WEST SUSSEX COUNTY COUNCIL CONSULTATION

TO:	Arun District Council FAO: Maria Tomalova
FROM:	WSCC - Highways Authority
DATE:	2 November 2021
LOCATION:	Rear of Green Gables, Northfields Lane, Westergate, PO20 3UH
SUBJECT:	AL/121/21/PL Demolition of swimming pool buildings and erection of 1 No. new dwelling using the existing access. This site is in CIL Zone 2 & is CIL Liable as new dwelling.
DATE OF SITE VISIT:	N/A
RECOMMENDATION:	Advice
S106 CONTRIBUTION TOTAL:	N/A

Drawing No.	2021-6321-001	Rev.	C
-------------	---------------	------	---

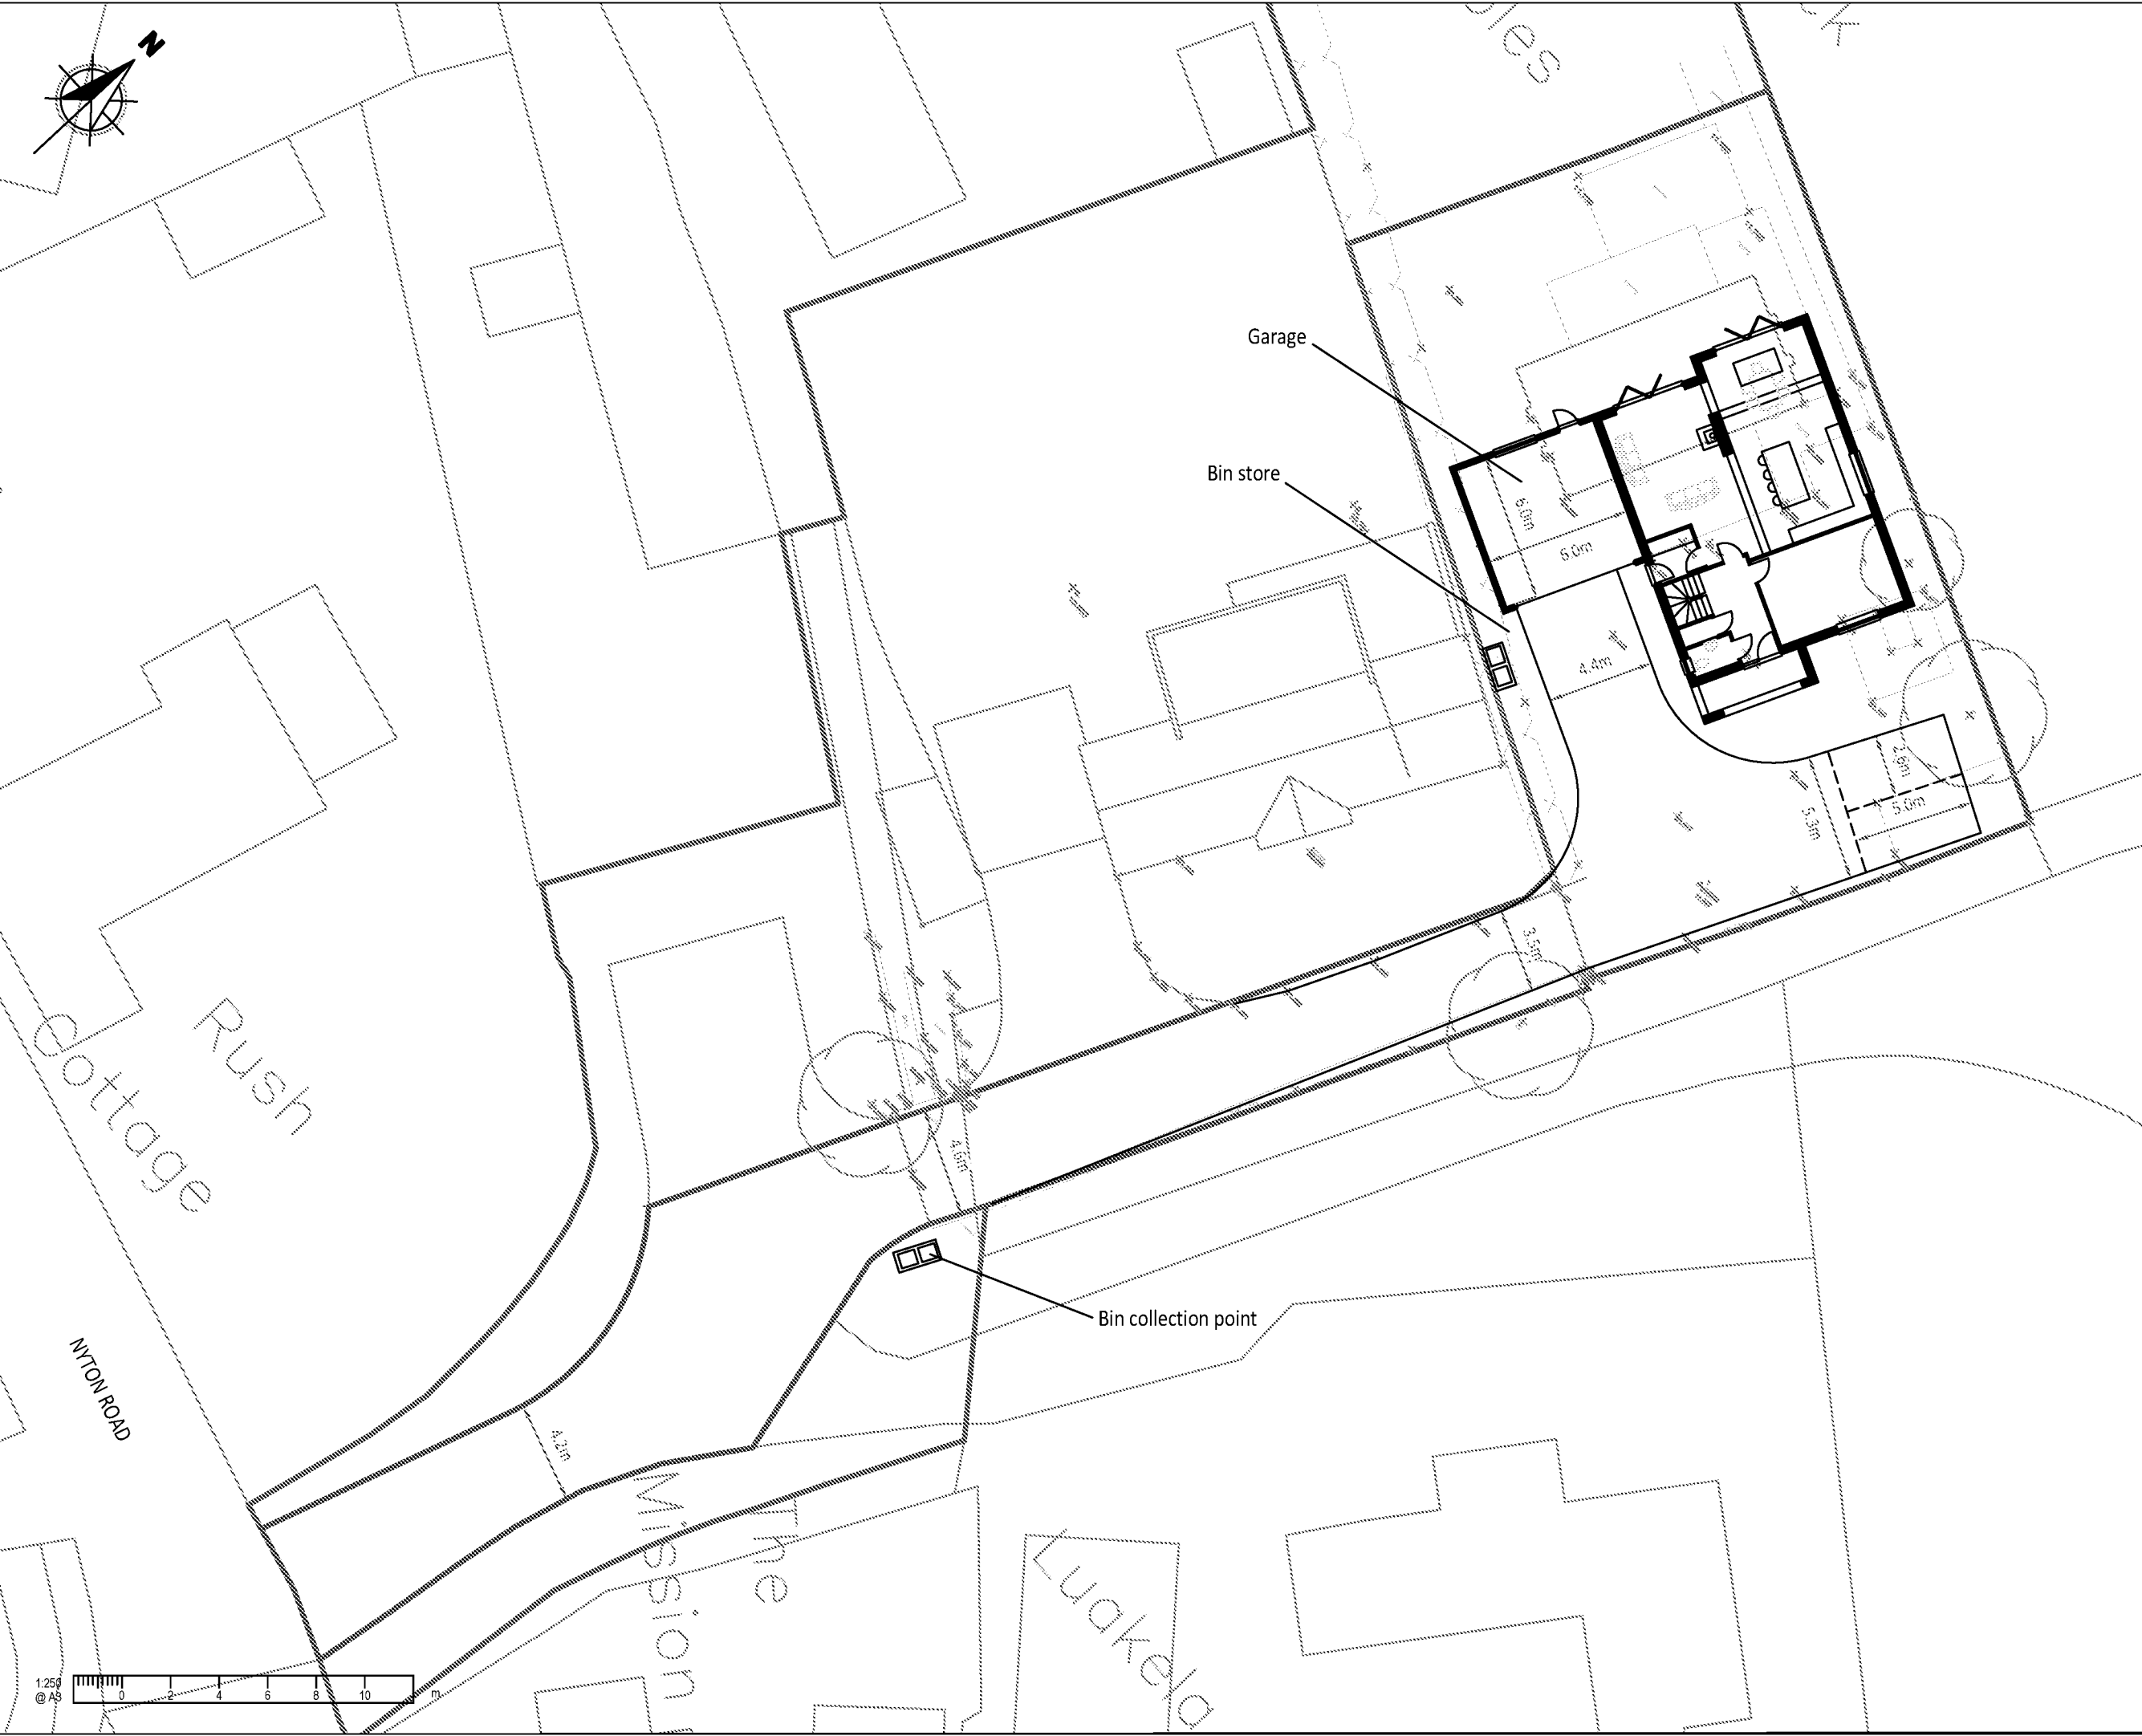
The applicant proposes four car parking spaces for this development, comprising of a double-bay garage and two additional parking bays within the driveway. Under Arun Parking Standards, the LHA would expect a dwelling of this size in this location to provide at least three car parking spaces. Therefore, the LHA considers the proposed parking provision to be sufficient. From inspection of the plans, the proposed parking spaces are suitably sized and on-site turning of a fire appliance has been demonstrated.

Car parking space (details approved)

No part of the development shall be first occupied until the car parking has been constructed in accordance with the approved site plan. These spaces shall thereafter be retained at all times for their designated purpose.

Site Plan

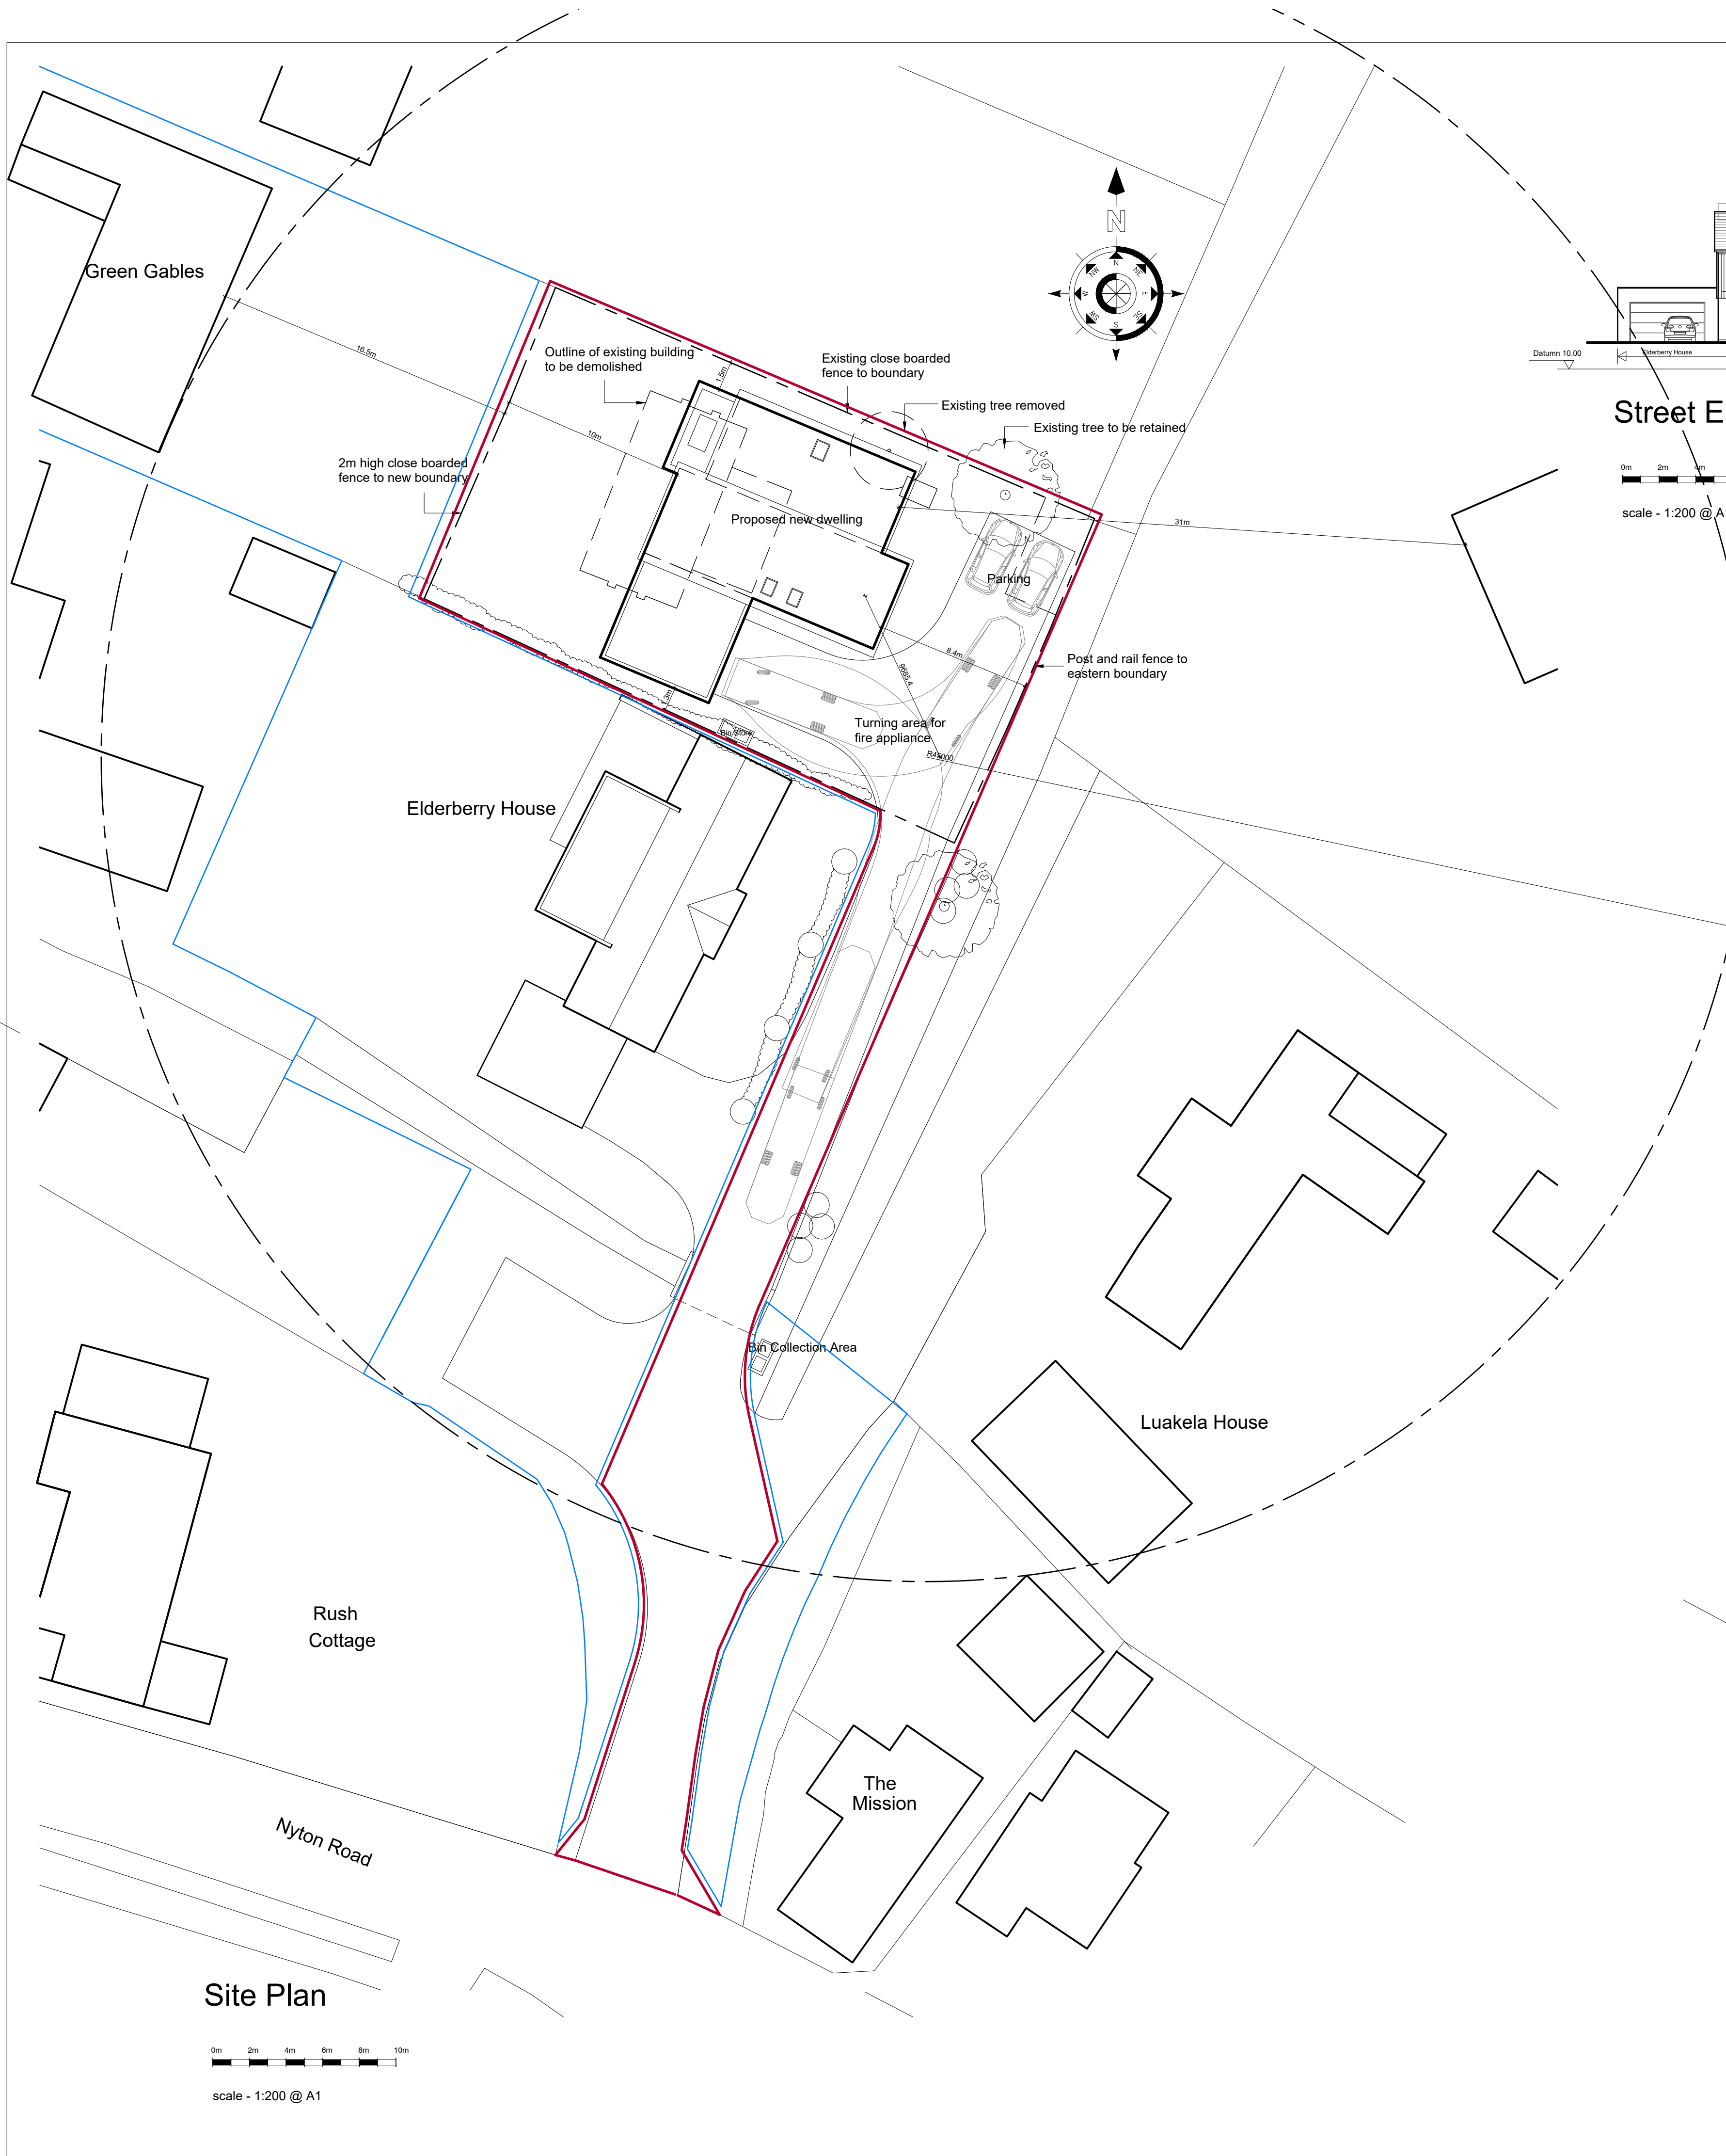
Regarding cycles, the proposed garage is of a suitable size to be considered for cycle parking provision. The garage is of sufficient size to accommodate at least two cycles, in accordance with Arun Parking Standards.
